2023/0621

Upward extension to convert property into chalet bungalow with increased roof height and size, new first floor windows to front and rear, single storey extensions to front, side and rear including new integral garage and front of dwelling parking area.

34 Osprey Avenue, Birdwell, Barnsley, S70 5SH

Elevations & Typical Section

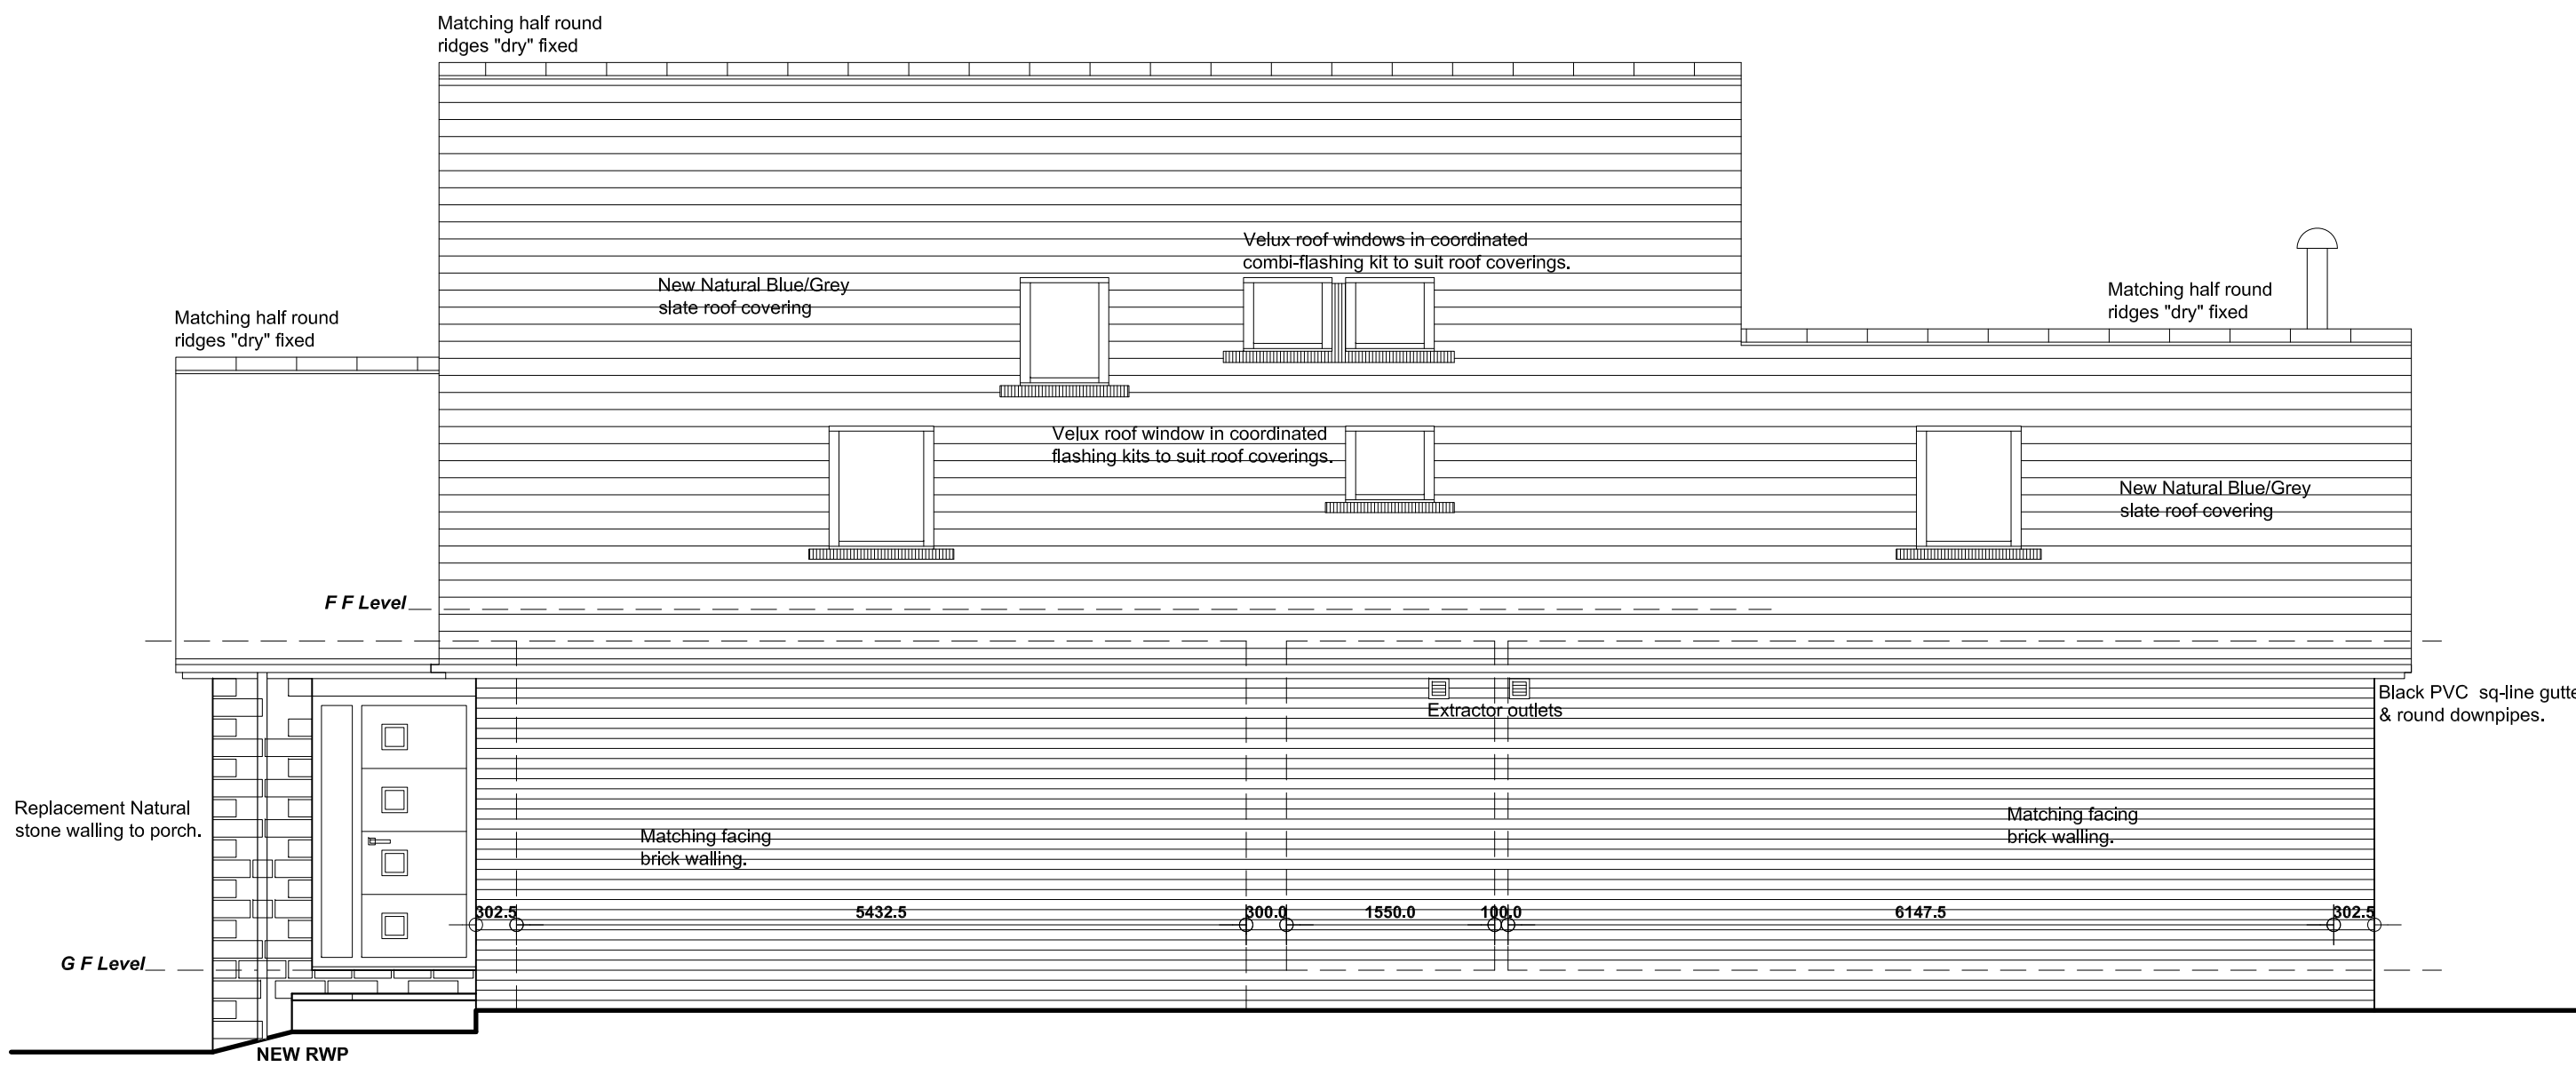
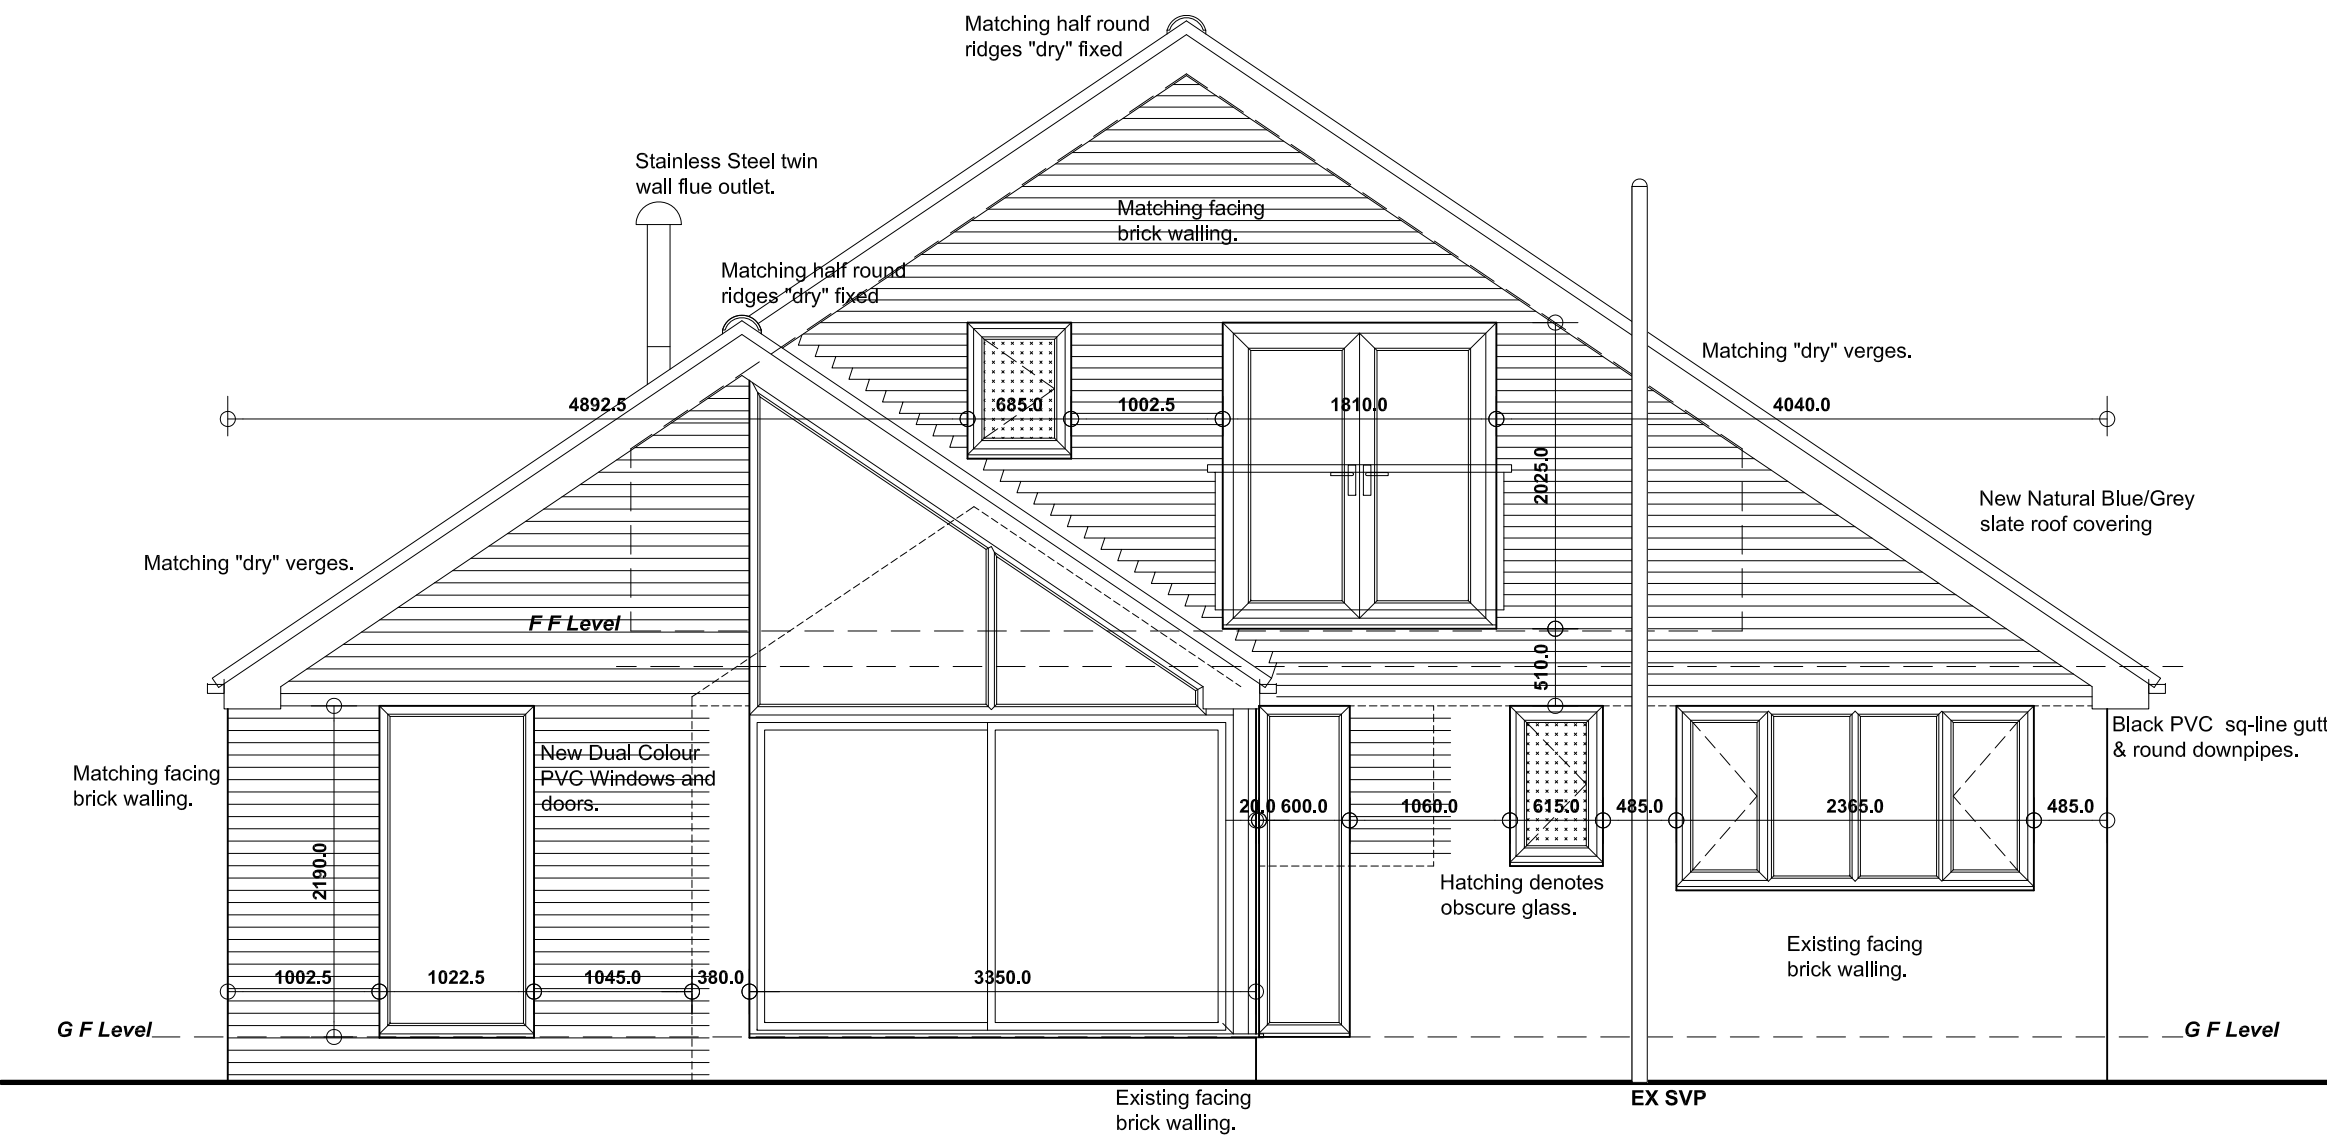
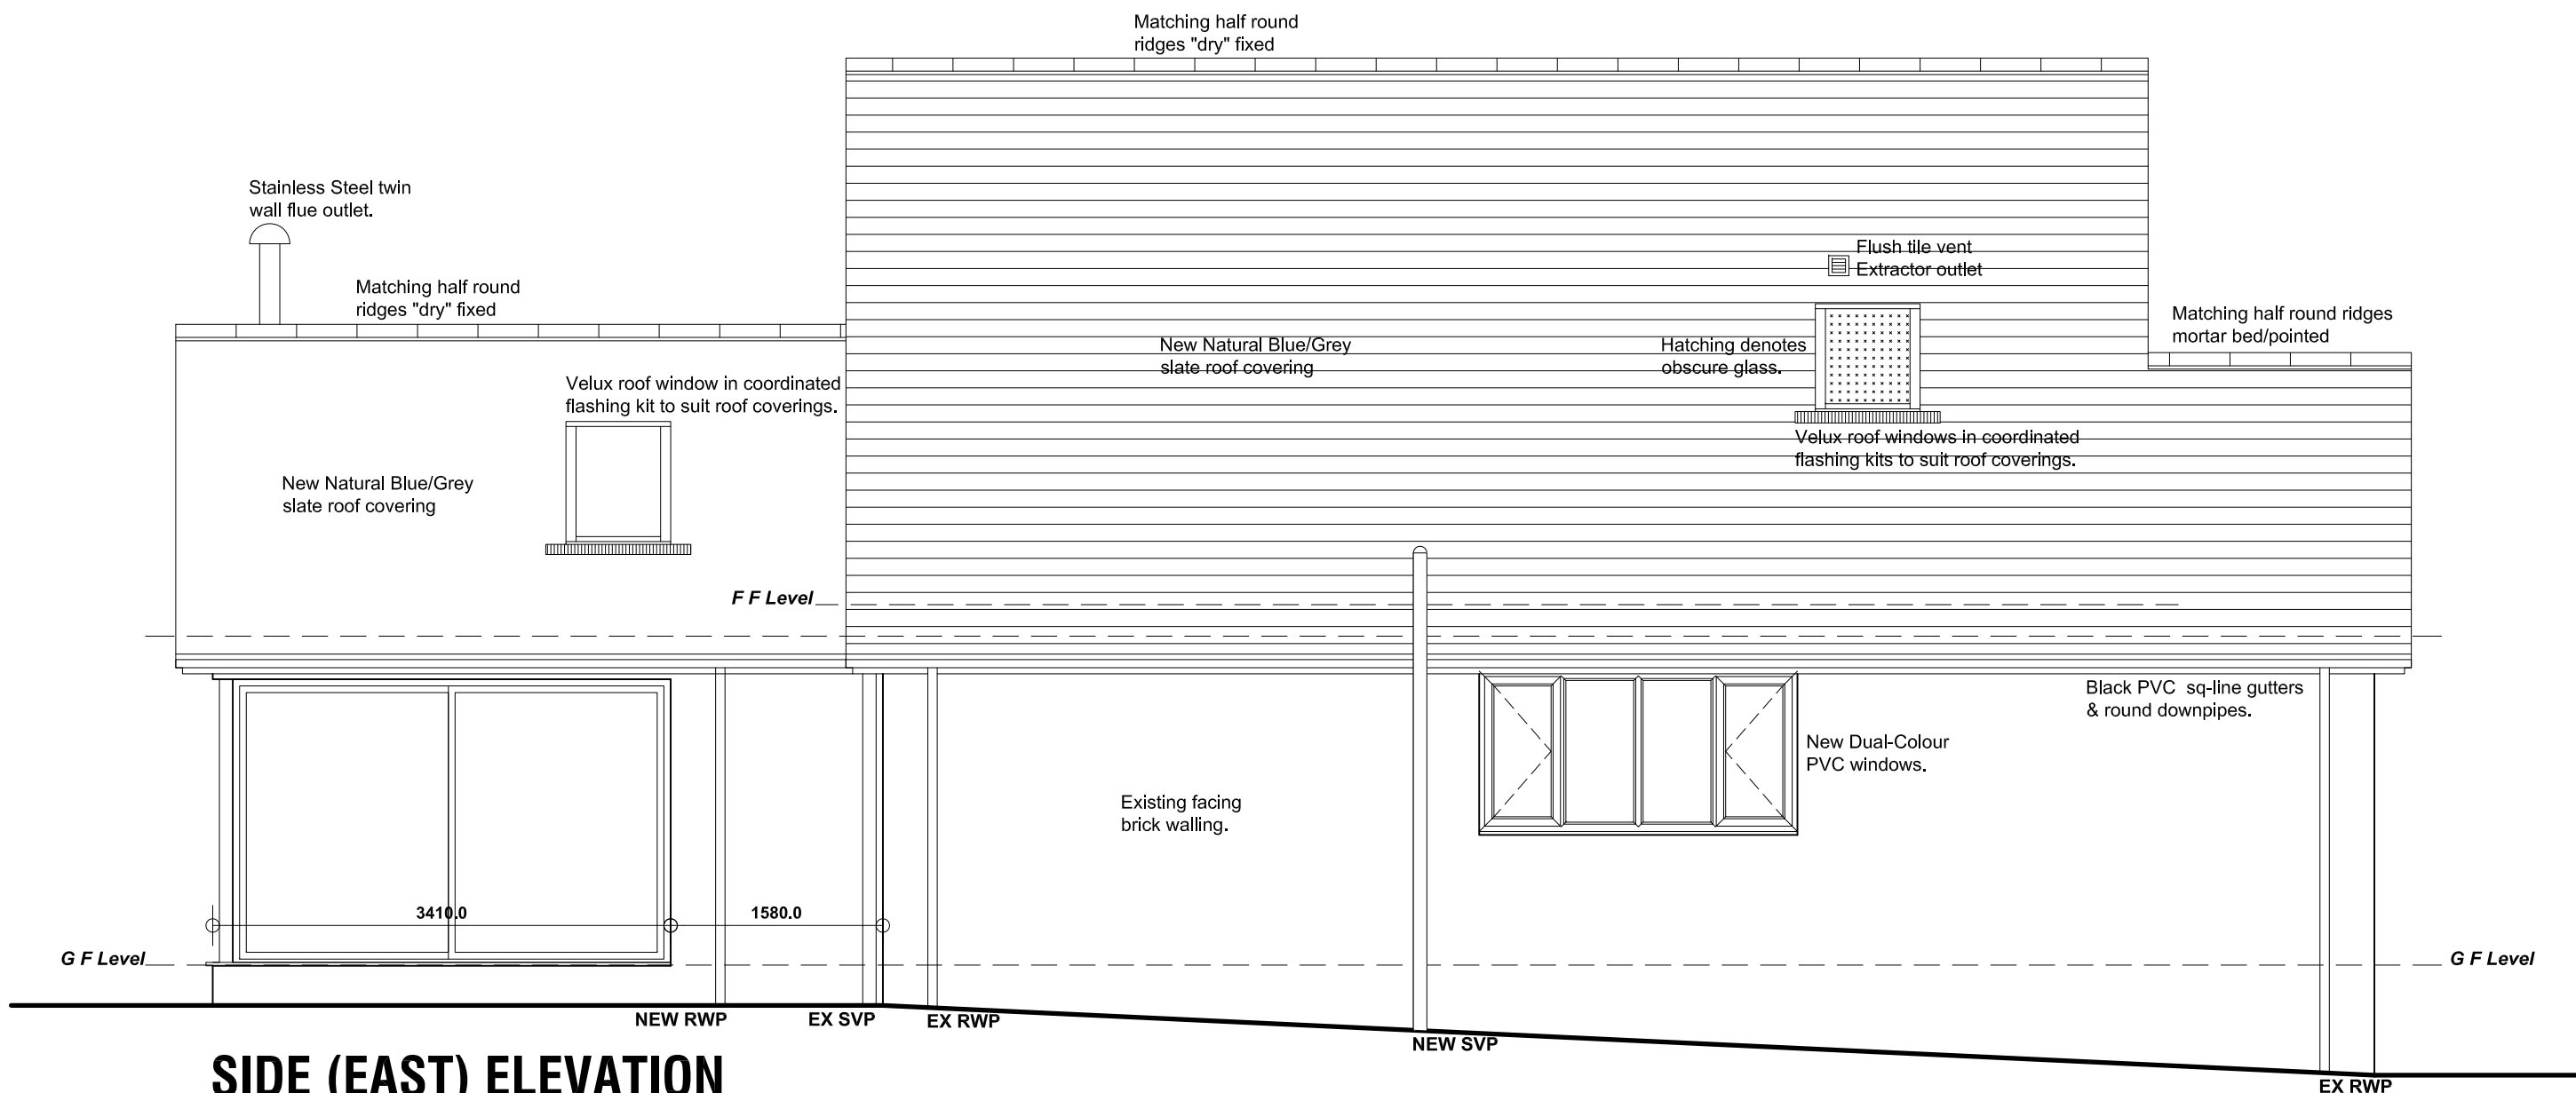
It is proposed to increase the ridge height by approximately 1.2m and change the style from a hipped roof to a chalet style gabled roof, as mentioned previously, there is no uniform house style within Osprey Avenue, whilst the properties are all single storey, they have differing ridge heights and utilise room in the roof space with the inclusion of dormer windows. Therefore, whilst it is proposed to increase the ridge height of the dwelling, it would not be out of character with the area, in addition the pitch of the proposed roof is not dissimilar to those of the neighbouring dwellings, further harmonising the dwelling into its surroundings. The proposed roof alterations also incorporate the flat roof of the existing attached garage, which is currently at odds with the hipped roof dwelling.

The current dwelling is constructed from a mix of materials which includes red/brown brick, buff brick, and artificial stone cladding. The use of the materials within the front elevation, is somewhat distinctive with a mix of several materials and colours. However following several design iterations it was considered that the use of materials put forward within the amended plans was the most harmonious possible whilst utilising the same as existing.

The increase in height would result in the inclusion of the habitable room windows within both the front and rear elevations, however the alterations would not result in these windows projecting closer to the respective boundaries, with a minimum of 21m being retained to the habitable room windows in the opposing property and given that there are no properties located to the rear would not increase levels of overlooking.

The extension to the north-eastern side elevation would project closer to the side boundary with 36 Osprey Avenue, and the inclusion of sliding doors on this elevation could result in some increase in overlooking. However, the extension is located a sufficient distance from the boundary with the existing boundary treatment providing adequate levels of screening.
